From: [Joe Dietzel](#)
To: [Kelly Bacon \(CD\)](#)
Subject: FW: [Ext] CU-22-00003 Brethren Frontier School - Notice of Application
Date: Monday, September 26, 2022 1:32:07 PM

CDS is requesting comments on the following Condition Use Application: CU-22-00003 Brethren Frontier School. Links to the file can be found below. Attached please find the Notice of Application and the SEPA Checklist. Kittitas County anticipates issuing a DNS for this project and is using the optional SEPA process under WAC 197-11-355. This may be the only opportunity to comment on the ecological impacts of this project. The comment period will end **Friday, September 30, 2022 at 5:00pm (PDT). CDS will assume your agency does not wish to provide comment if not received by this date.**

1061 EMERSON RD
PROPOSED MULTI PURPOSE BLDG
1" = 10'

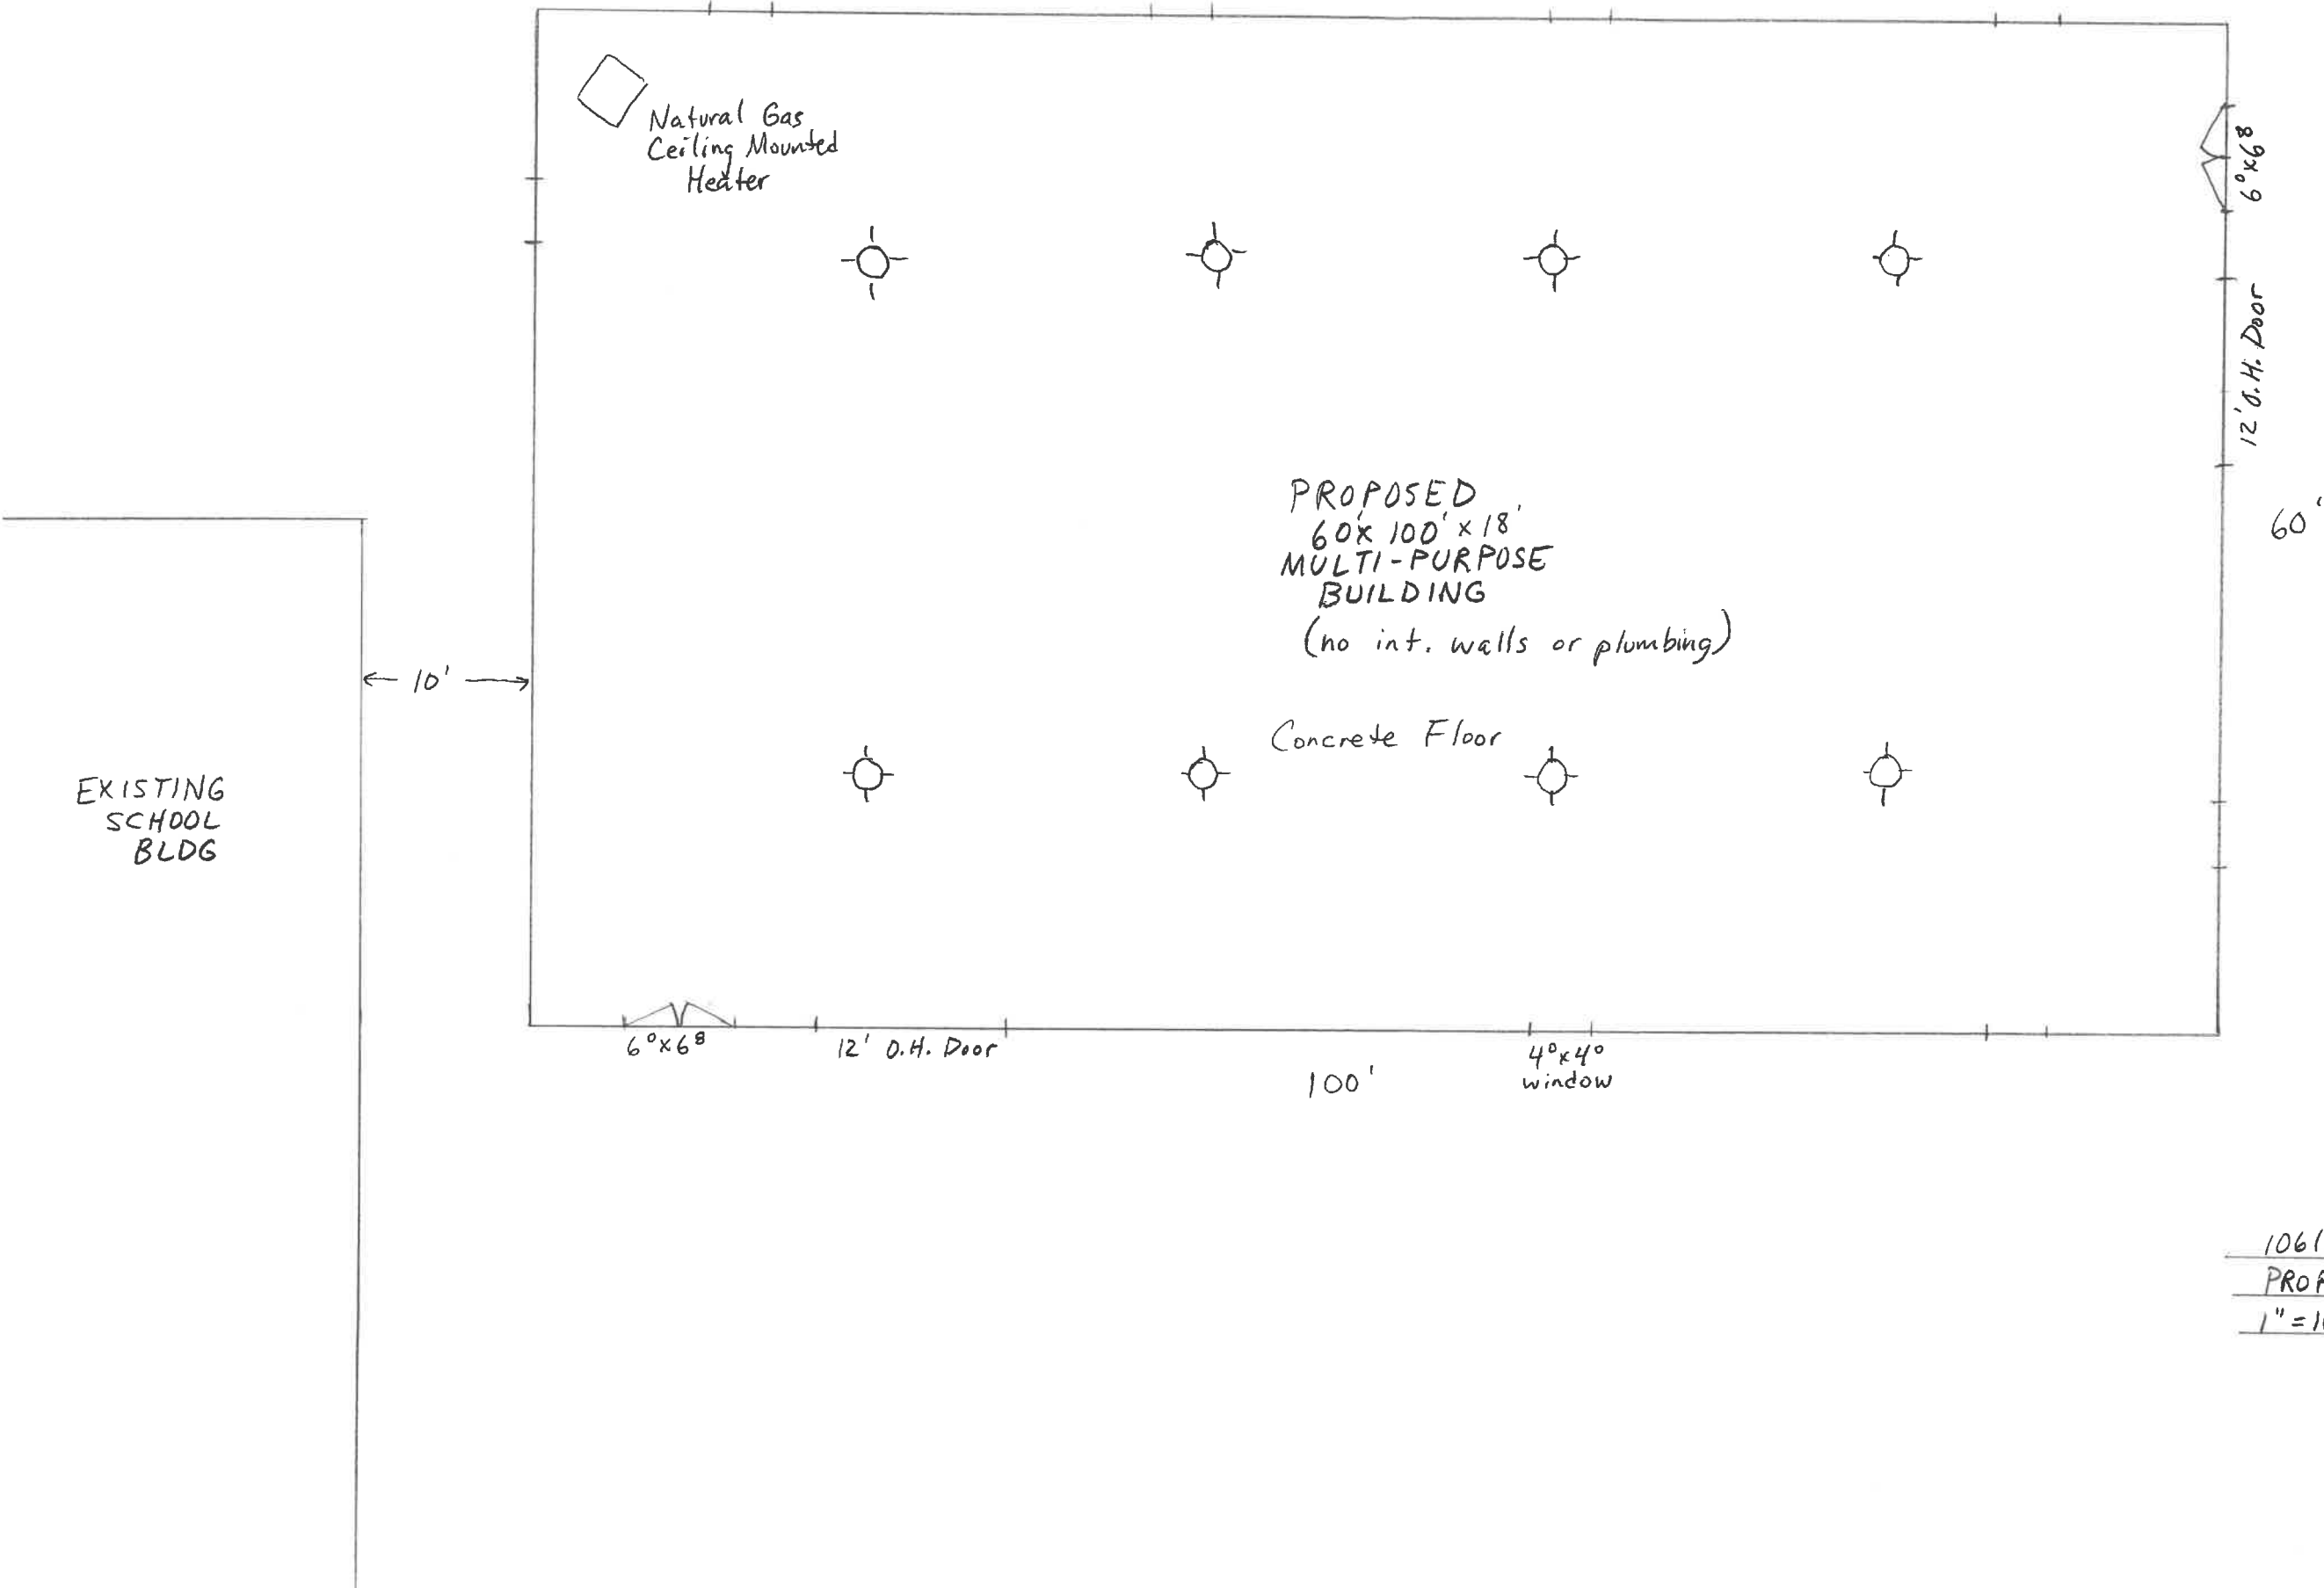
Both Captain Delvo and I discussed the reality that the large assembly building will likely be used for more than the proposal suggests. This is my concern – once occupancy is granted, absent clear restrictions on use, this will morph into something that would require suppression and/or additional alarm systems.
